From: Colin Sharpe
Sent: 25 October 2012 14:09
To: Jane Tucker
Subject: FW: Consultation on planning application 3/2012/0738 land off Dale View, Billington

From: Hornby, Mark [mailto:Mark.Hornby@lancashire.gov.uk]
Sent: 25 October 2012 14:01
To: Colin Sharpe
Subject: FW: Consultation on planning application 3/2012/0738 land off Dale View, Billington

Proposed Location Plan 1:1250

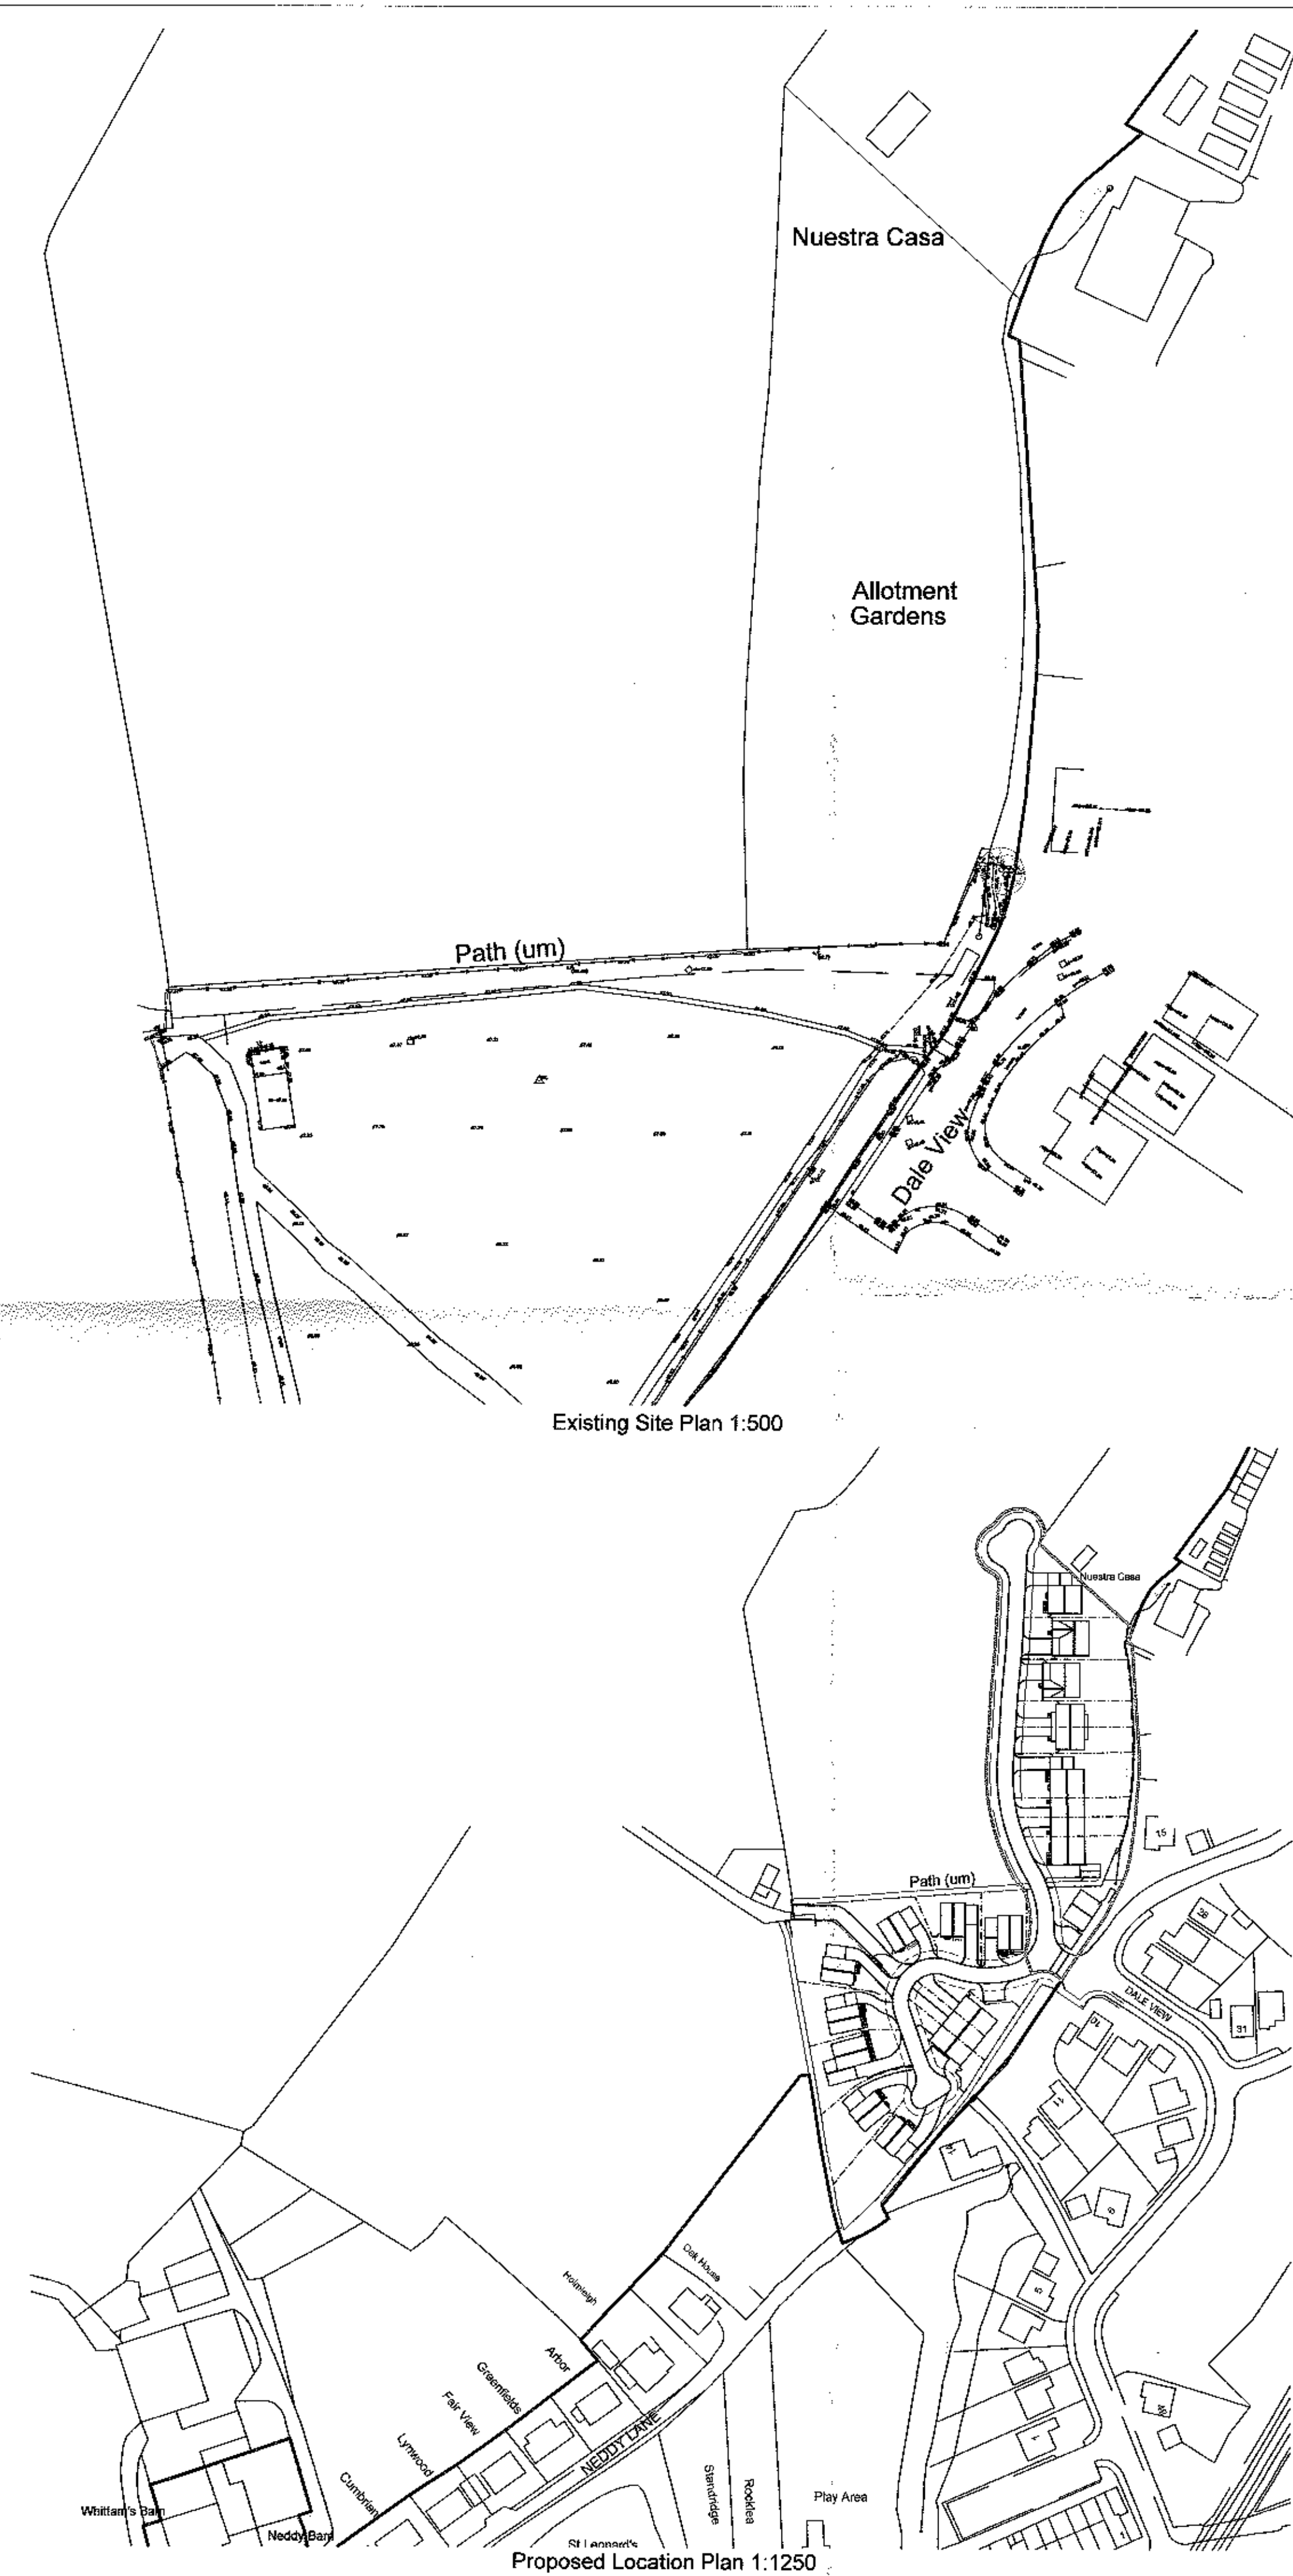
This is an outline planning application and details of the internal highway layout are at present described as indicative, however it is assumed that the intention is for the highway infrastructure within the development site to be adopted by the Highway Authority, in which case an agreement under Section 38 of the Highways Act will be required between the developer and Lancashire County Council.
